# Rezoning Transportation Analysis

Petition Number: Insert Zoning Petition #2021-023

General Location Identifier: Tax IDs: 22327148, 22327149, 22327150, 22327151, 22327152

## Revision Log:

DEVELOPMENT STANDARDS March 15, 2021

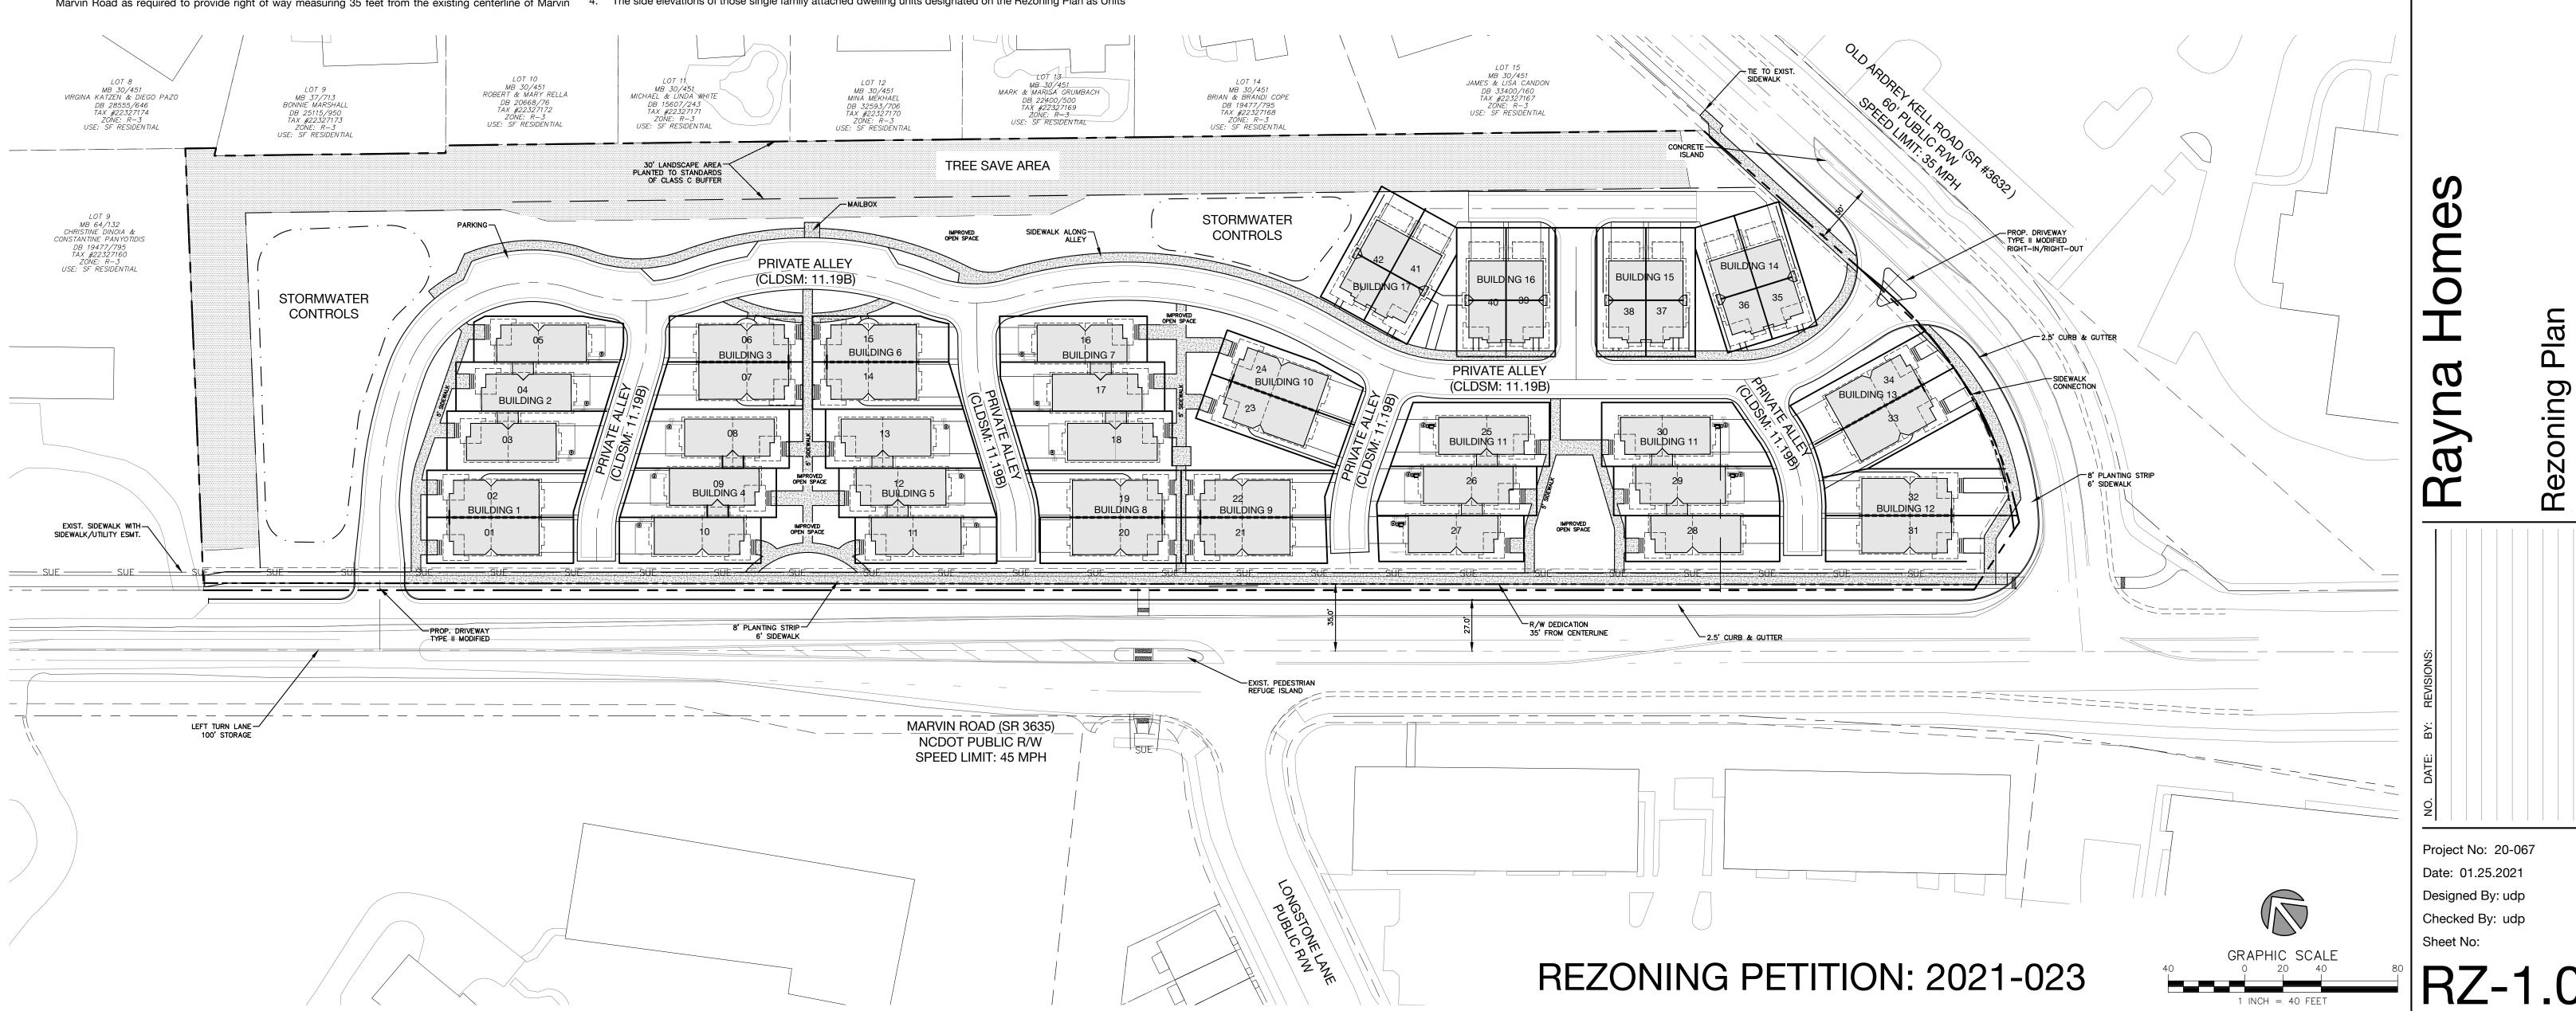
1. ~~Curbline:~~ The proposed zoning district has a setback measured from back of the existing or proposed future curbline.
  - a. **Resolved (03/18/2021): Marvin Road (NCDOT):** The future location of back of curb and gutter is 27' from the Marvin Road centerline. Label and dimension the curb and gutter from the centerline for each road on the site plan.

- b. **Resolved (03/18/2021): Old Ardrey Kell Road (NCDOT):** Location of curb and gutter is in its existing location.

Label and dimension the curb and gutter from the centerline for each road on the site plan.

3. **Resolved (03/18/2021):** ~~Revise site plan and conditional note(s) to commit to dedicate 35' right-of-way on Marvin Road from the road centerline. The site plan shall label and dimension the right-of-way from the road centerline.~~

4. **Resolved (03/18/2021):** ~~Revise site plan and conditional note(s) to commit to construct an 8-foot planting strip, and 6-foot sidewalk on Marvin Road and Old Ardrey Kell Road per Chapter 19 / Chapter 20. The site plan shall label and dimension both items from the back of curb and gutter and road centerline.~~

5. **Resolved (03/18/2021):** Provide a left turn lane on Marvin Road as required by NCDOT. Restripe Marvin Road, per NCDOT Roadway Standard Drawing for PAVEMENT MARKINGS Turn Lanes, 1205.05, to accommodate the left turning lane to include 100' storage.

6. **Resolved (03/18/2021):** Petitioner will relocate the driveway access point on Marvin Road, as shown per NCDOT, and provide 100' driveway stem.
7. **Resolved (03/18/2021):** Petitioner will relocate the driveway access point on Old Ardrey Kell Road. The access point will be a RI/RO with a porkchop median and a center median that will begin from the driveway across the street and continue to the end of the Left Turn Lane (LTL) taper to Marvin Road, as shown per NCDOT and provide 100' driveway stem.

8. **Resolved (03/18/2021):** Site plan and conditional note(s) revisions are needed to meet CLDSM standards as required by NCDOT. Provide a pedestrian refuge across Marvin Road, per CLDSM, 11.41, complying with ADA/PROWAG standards. The pedestrian refuge also meets the Charlotte WALKS Policy.

12. **Rescinded (5/11/2021):** ~~Based on feedback from the community, please revise the dimension of the concrete island proposed on Old Ardrey Kell Rd. to allow room for more left turn storage at the Old Ardrey Kell and Marvin Rd. intersection.~~
